Town & Country Planning Act 1990 (as amended)
Town & Country Planning (Development Management Procedure) (England) Order 2015 - Article 5

Application No: FP/274/21/OUT
Site Address: Bognor Regis Golf Club Downview Road Felpham PO22 8JD
Description of works: Outline planning application with all matters reserved, except means of access, for the erection of up to 480 new homes (C3), the formation of a new means of access onto Golf Links Road, together with the creation of new surface water drainage, new landscaping and habitat creation, ground works and other infrastructure and the retention and re-purposing of the retained club house (F2). This site also lies within the parish of Yapton, affects a Public Right of Way and is a Departure from the Development Plan. This application is subject to an Environmental Statement.

Thank you for your internet representation made on 7th April 2022 which has been recorded as an objection with the comments as follows:

designed by	checked by	date
LJM	NJE	14 Dec 21
scale	paper size	
1:2000	A1	
job/dwg no.	rev.	
171-UW-P-A-009	A

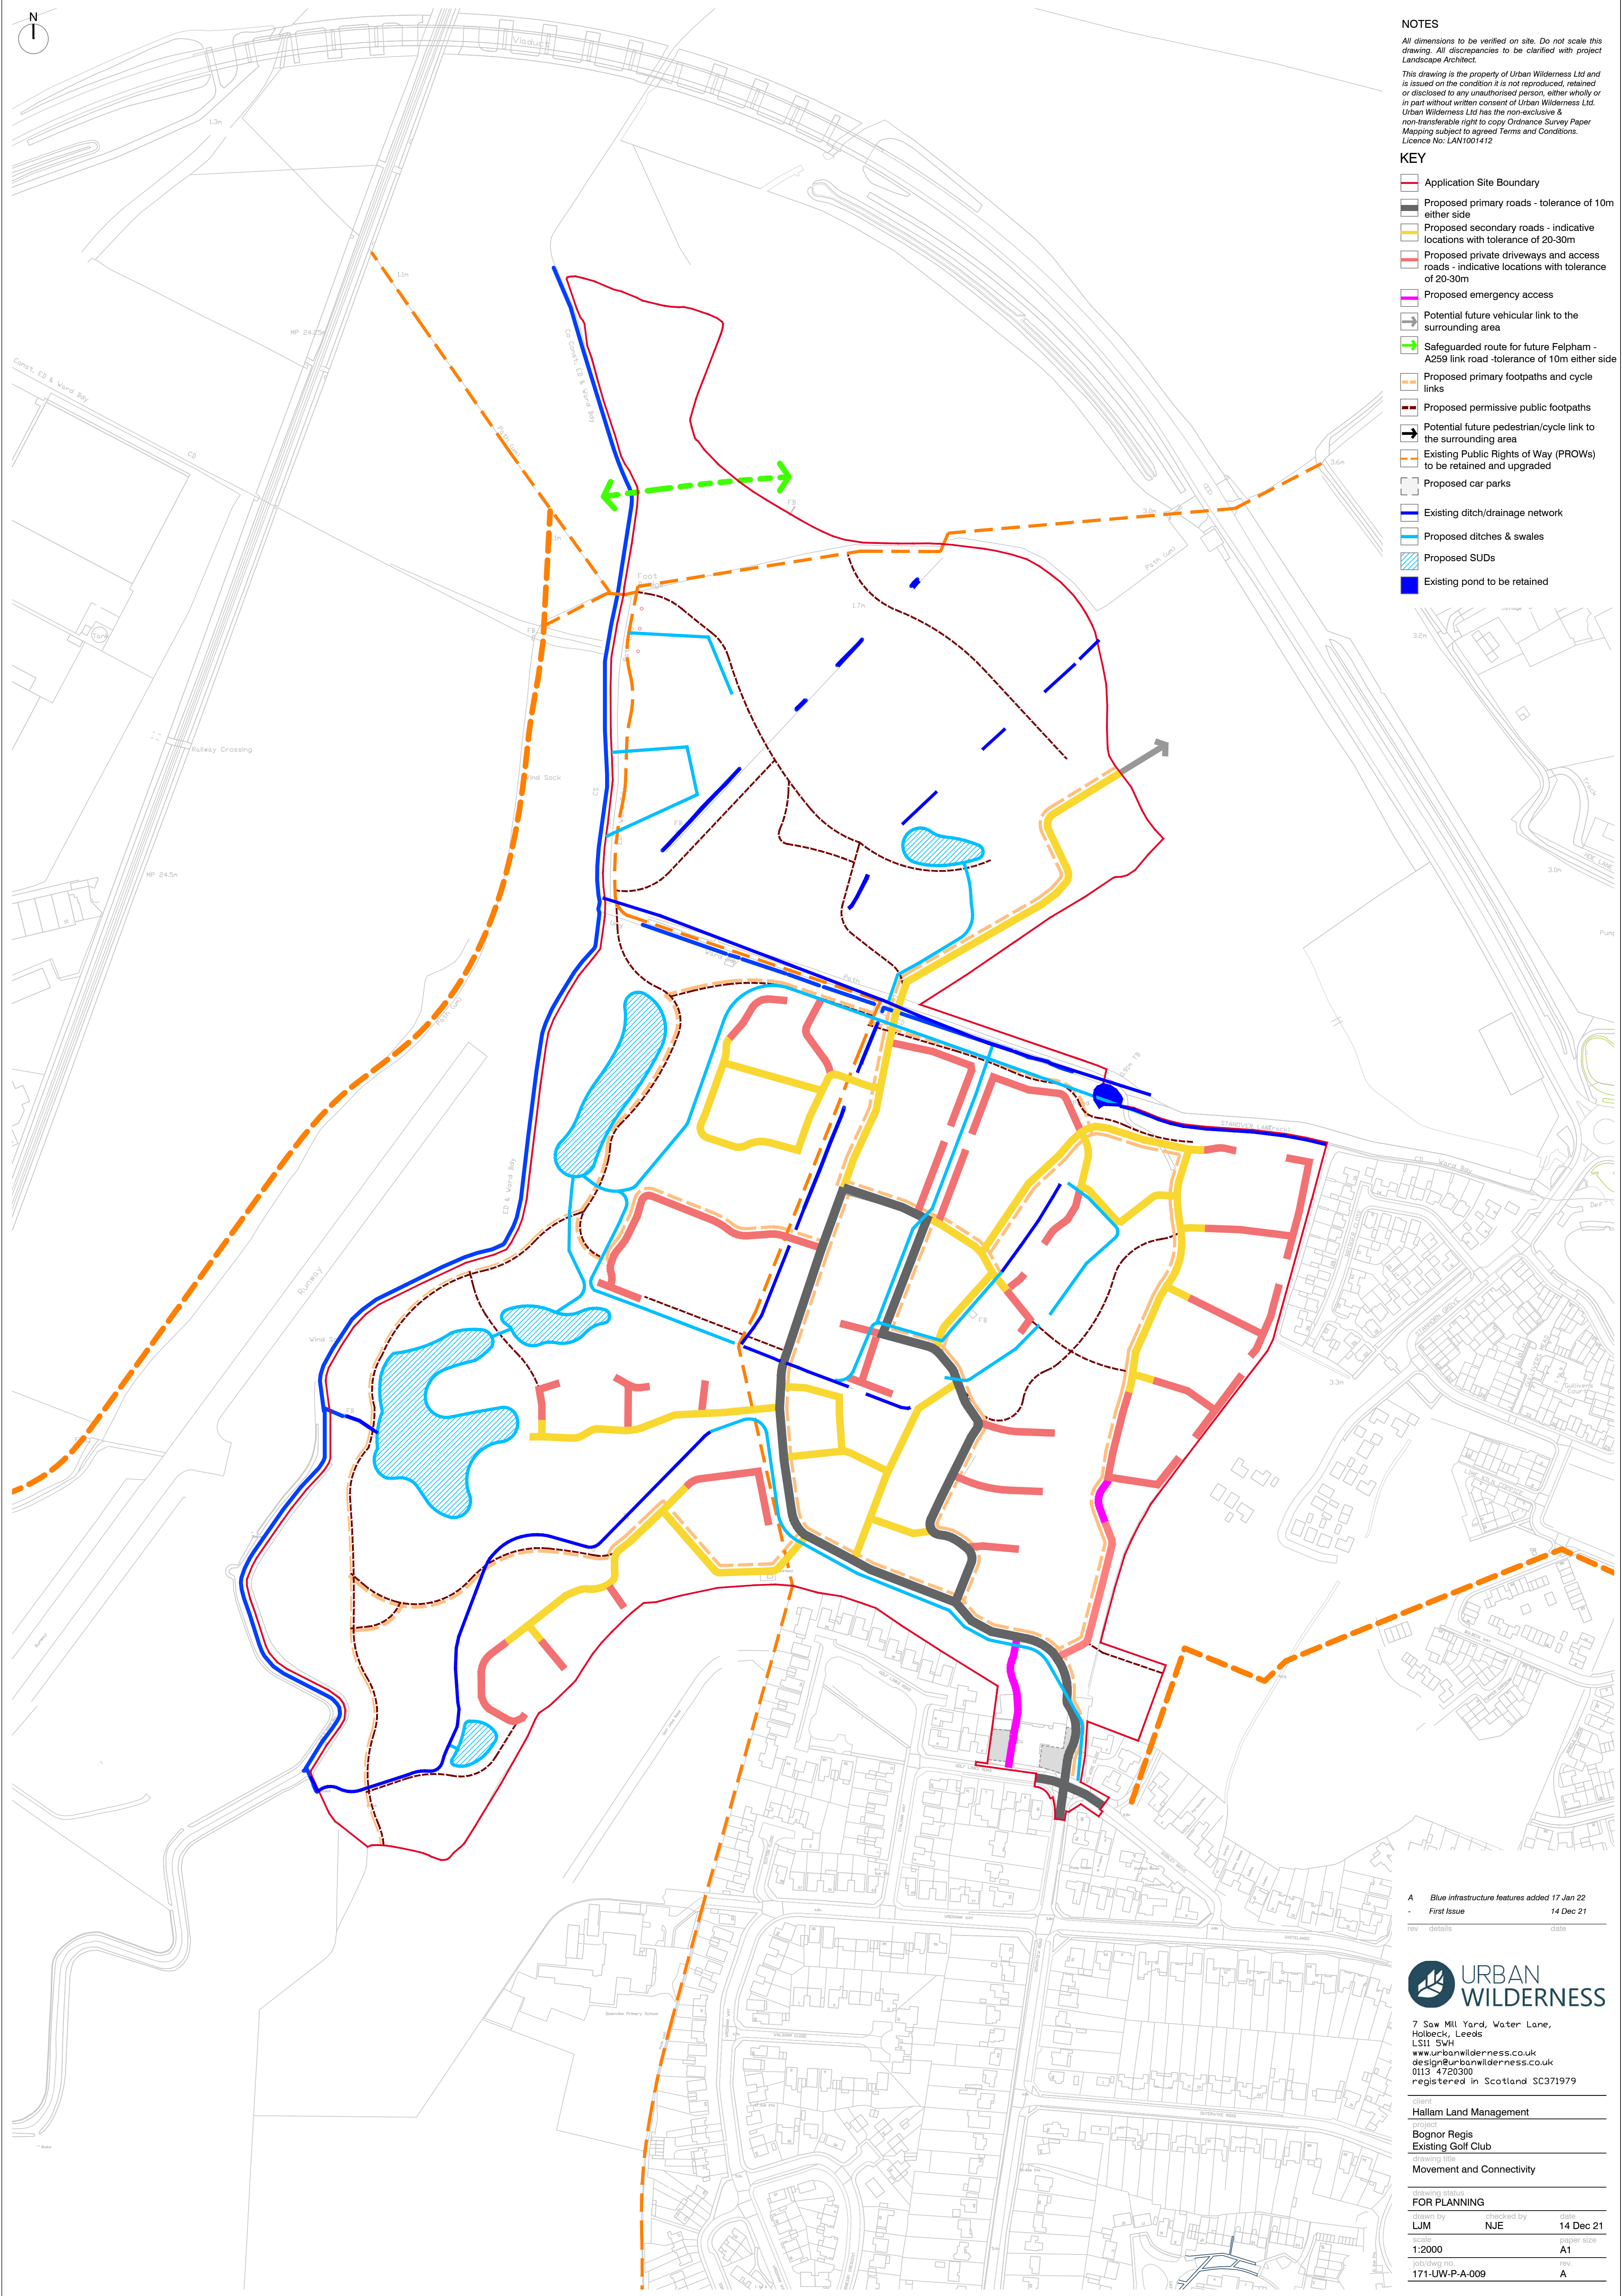
5. The Application's Movement and Connectivity Plan (Drawing 171-UW-P-A-009) shows an arrow for the location of a "potential future vehicular link to the surrounding area" on the north east boundary of the site. The arrow points directly to the A259 Relief Road and is located at the end of proposed primary and secondary roads that lead directly to Downview Road. This would result in Downview Road becoming an access route to the Relief Road and would attract very large volumes of traffic totally unsuitable for a residential road. It would also negate all the benefits of reduced traffic on the B2259 delivered by the Relief Road.
